RESPONSE TO SUBMISSIONS: WENTWORTHVILLE NORTHSIDE WEST CLINIC EXTENSION

23-27 LYTTON STREET, WENTWORTHVILLE
LOT 1 DP787784

RESPONSE TO SUBMISSIONS REPORT

SSD-17899480

1 Shadow Diagram Existing\_Winter Solstice 0900  
 Scale: 1 : 1000

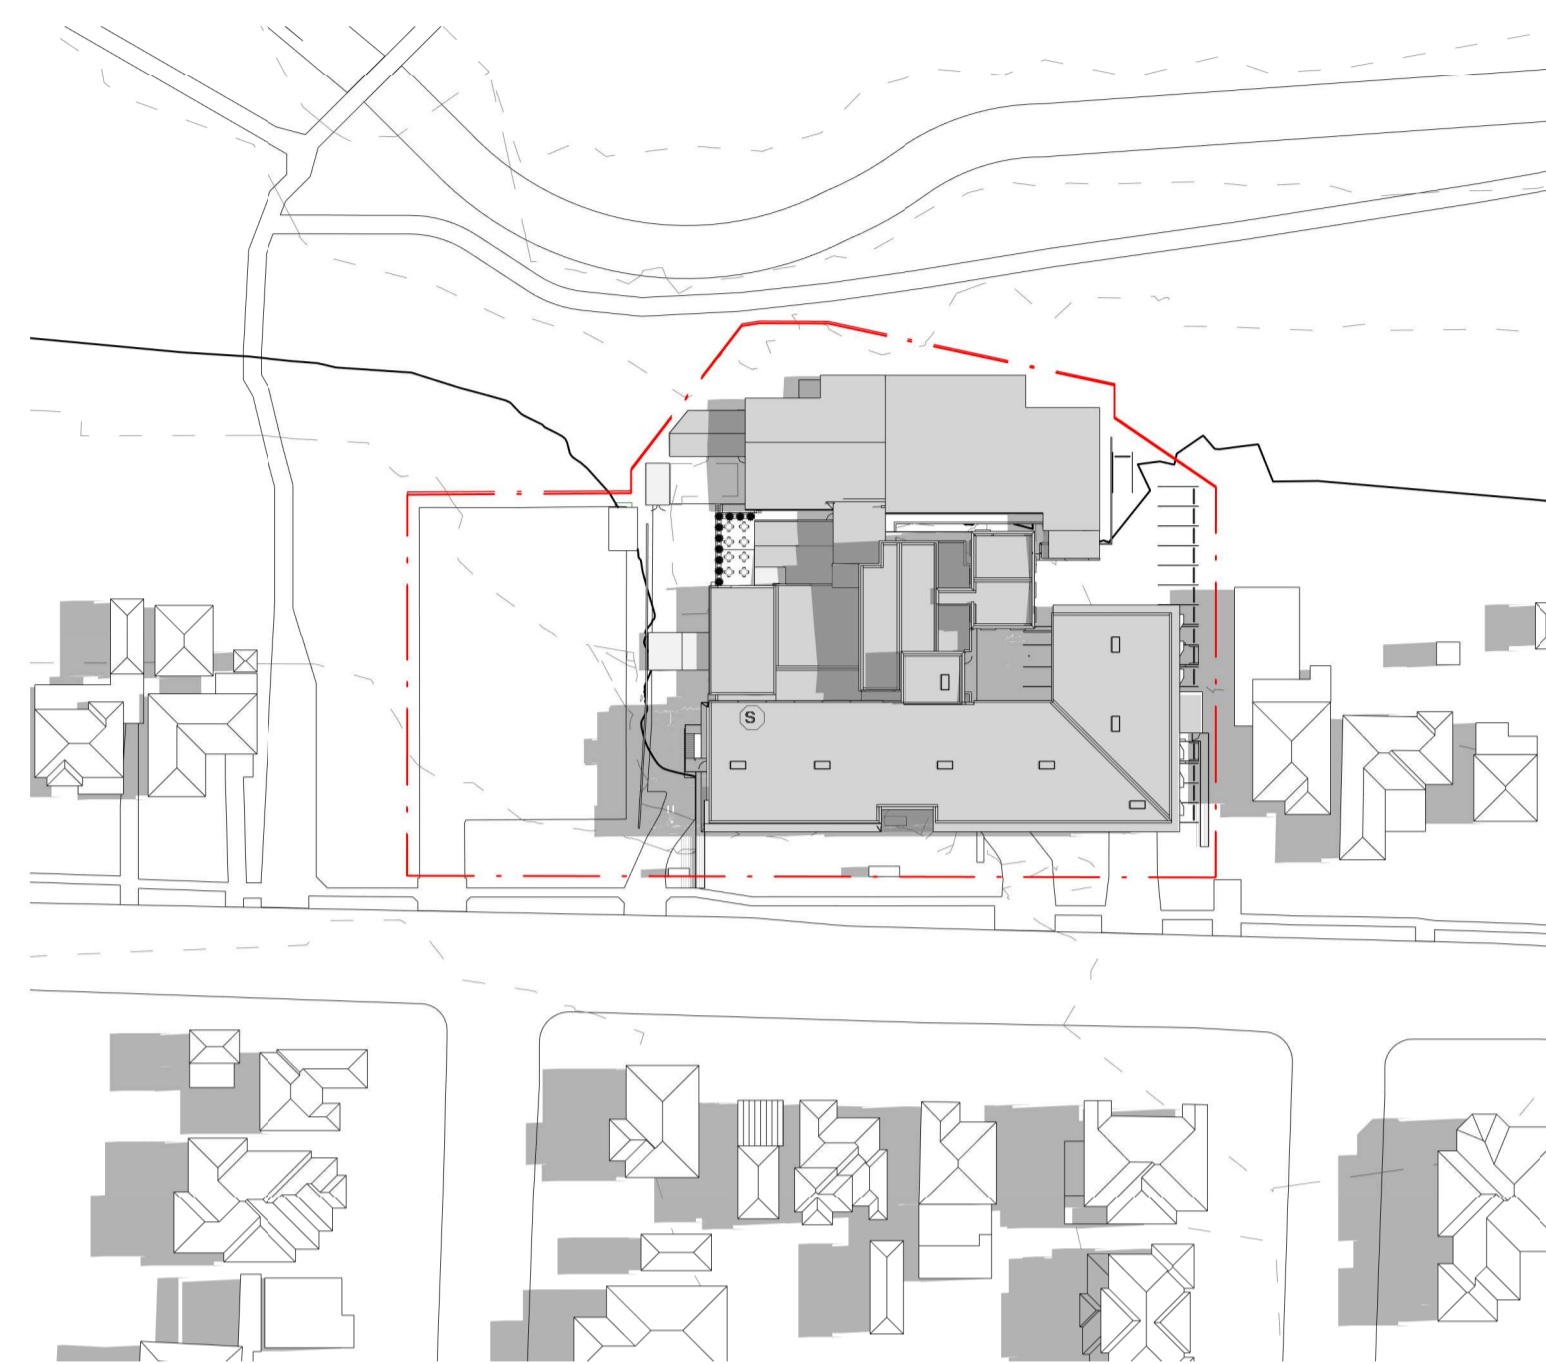
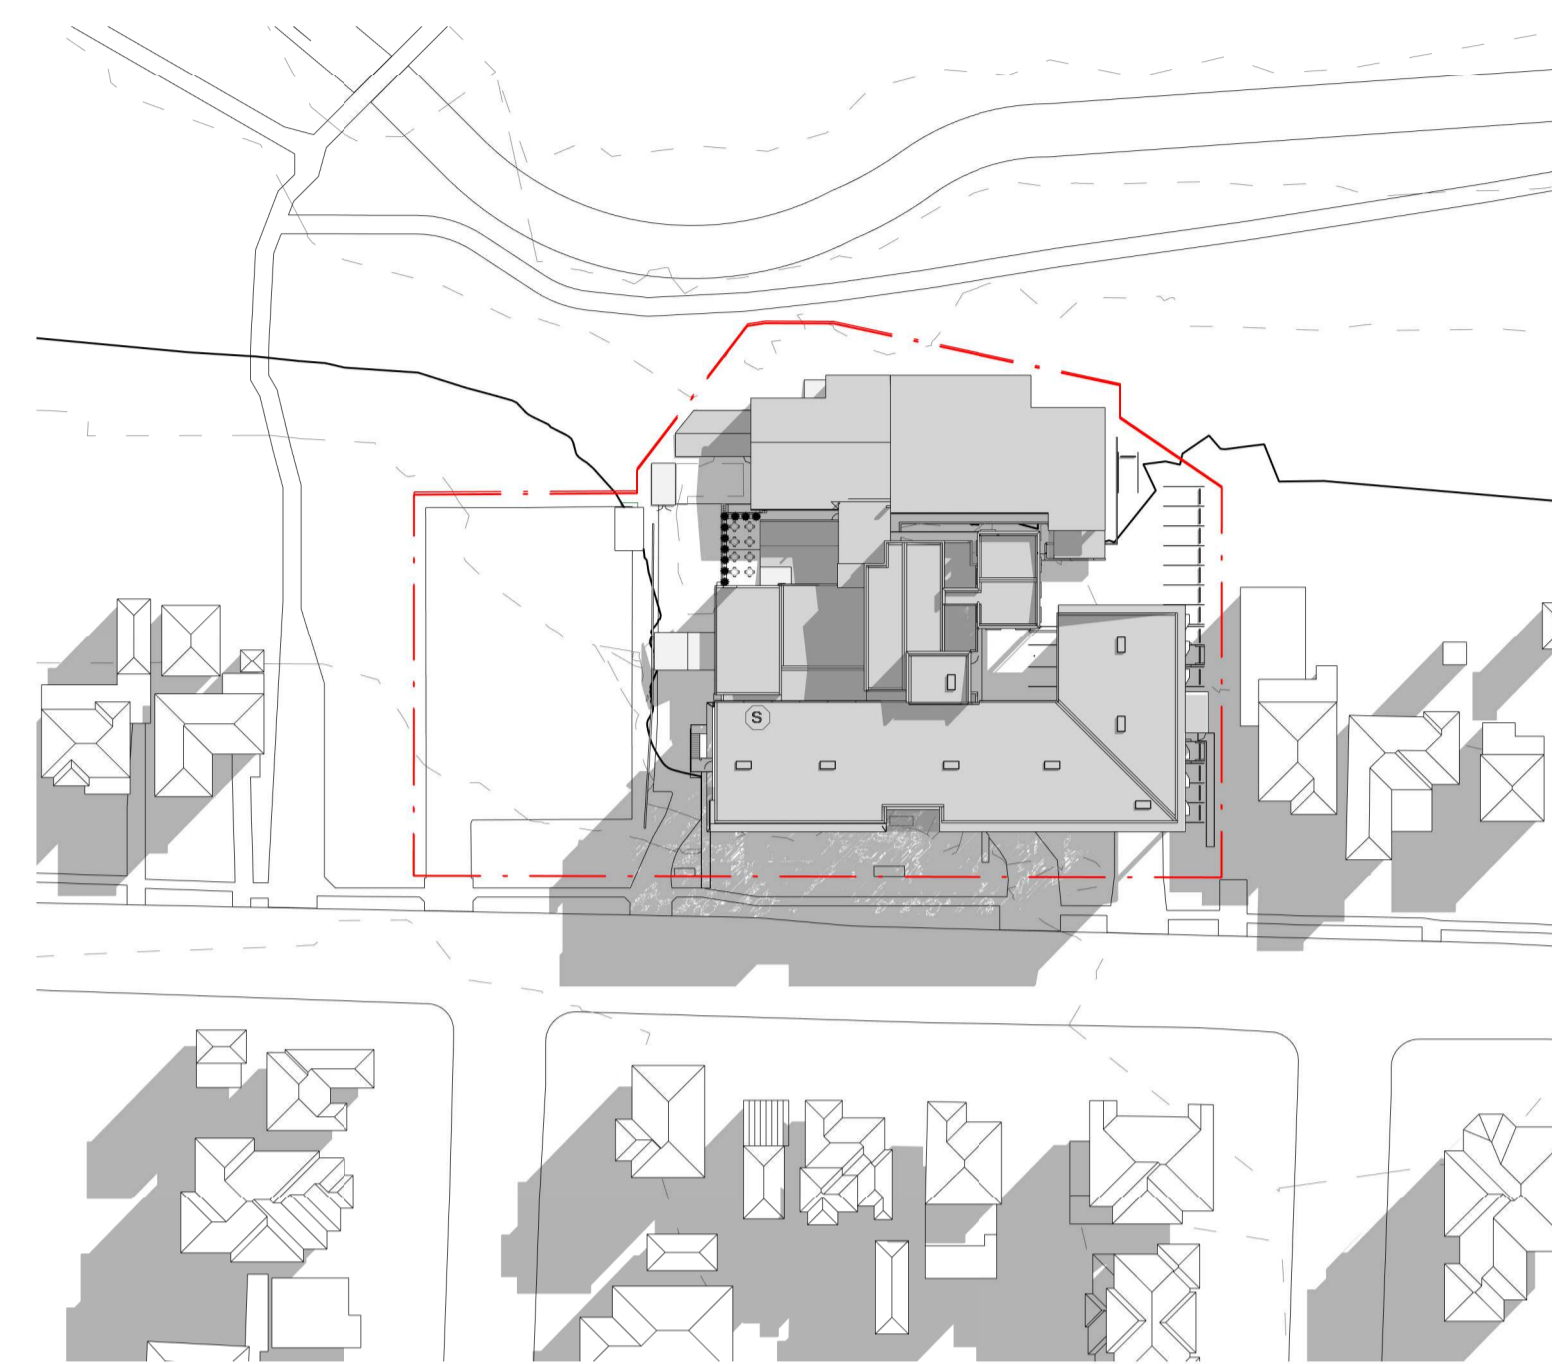
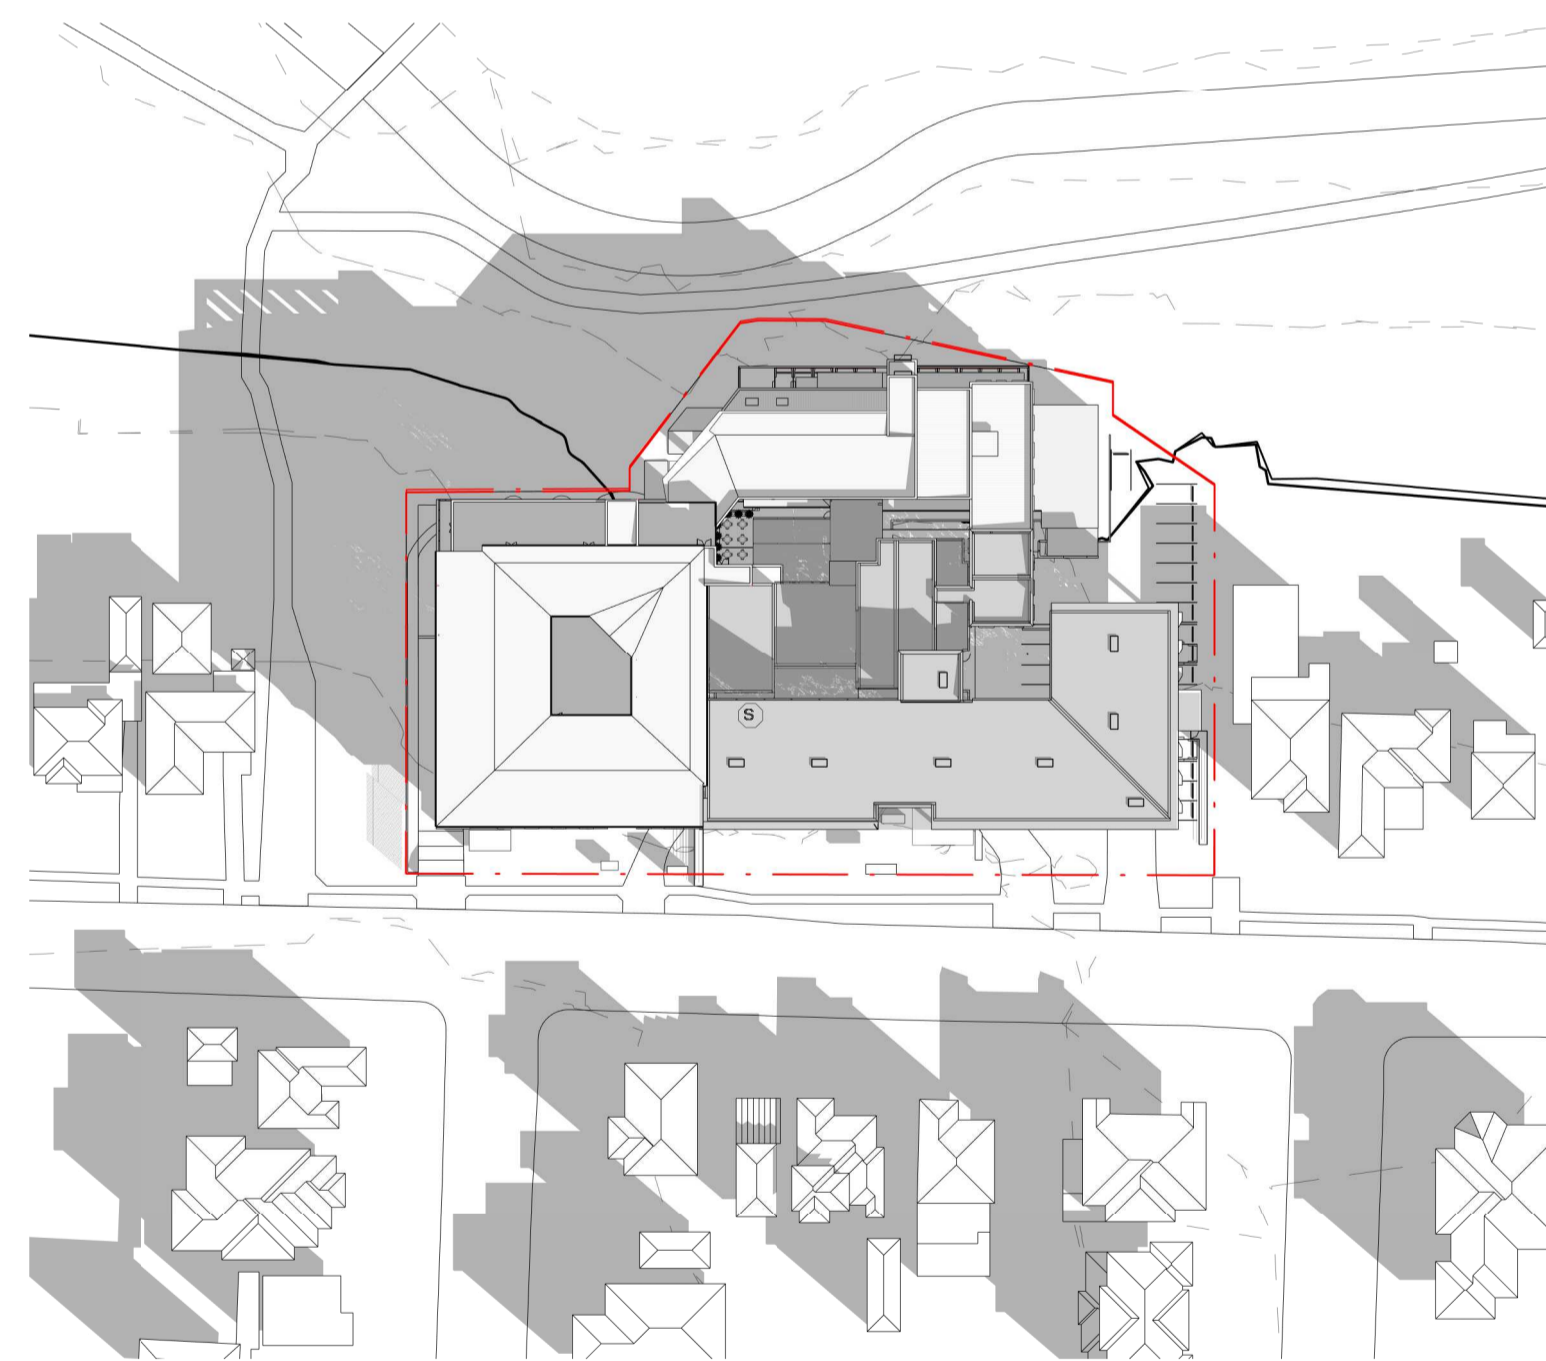
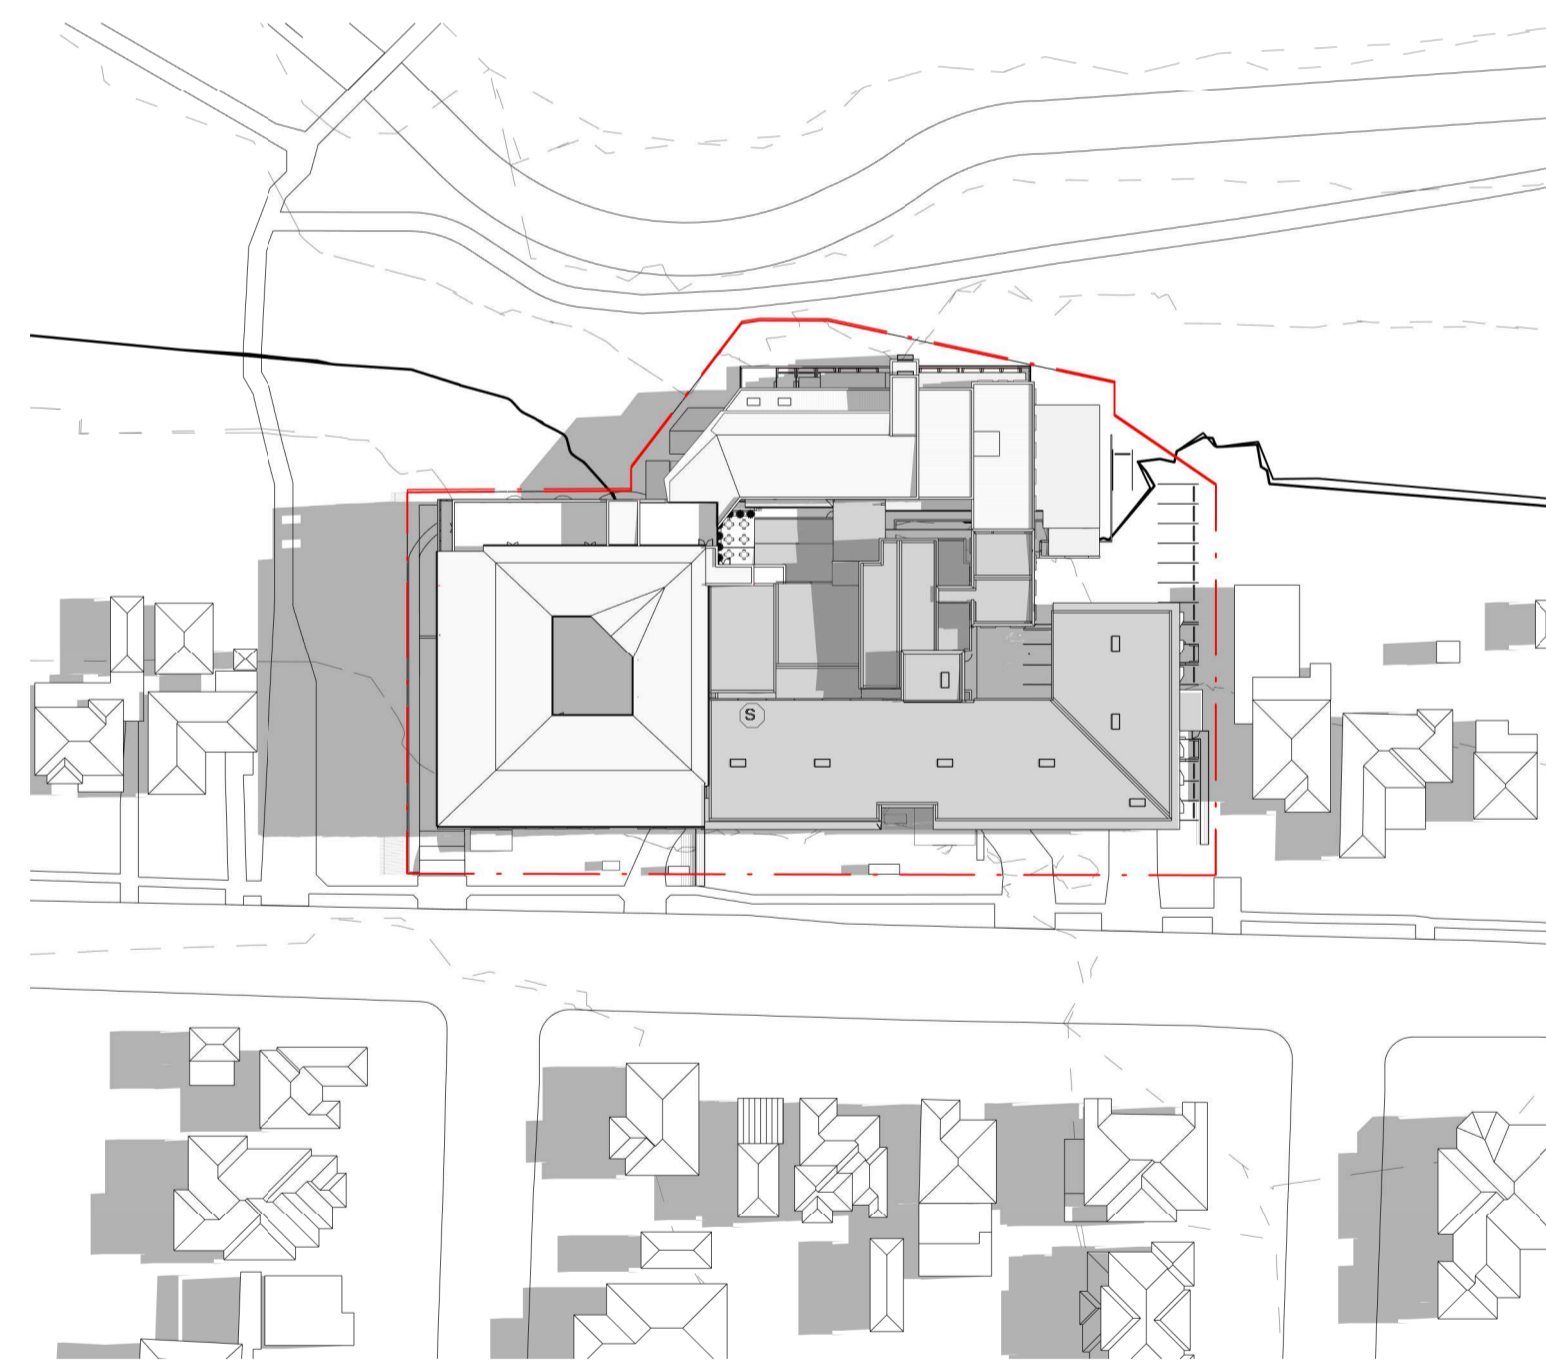
<ul style="list-style-type: none"> ○ demonstrate the overshadowing which would be created by the hanging planters, ensuring adequate solar access is experienced within this space and to internal rooms. 	<p>As illustrated in the Shadow Diagrams within the Architectural Plans, the courtyard and patient rooms will receive adequate solar access during summer solstice. It is noted that the patient rooms on Level 1 and 2 will continue to receive acceptable level of sunlight access on winter solstice. While the courtyard will be</p>
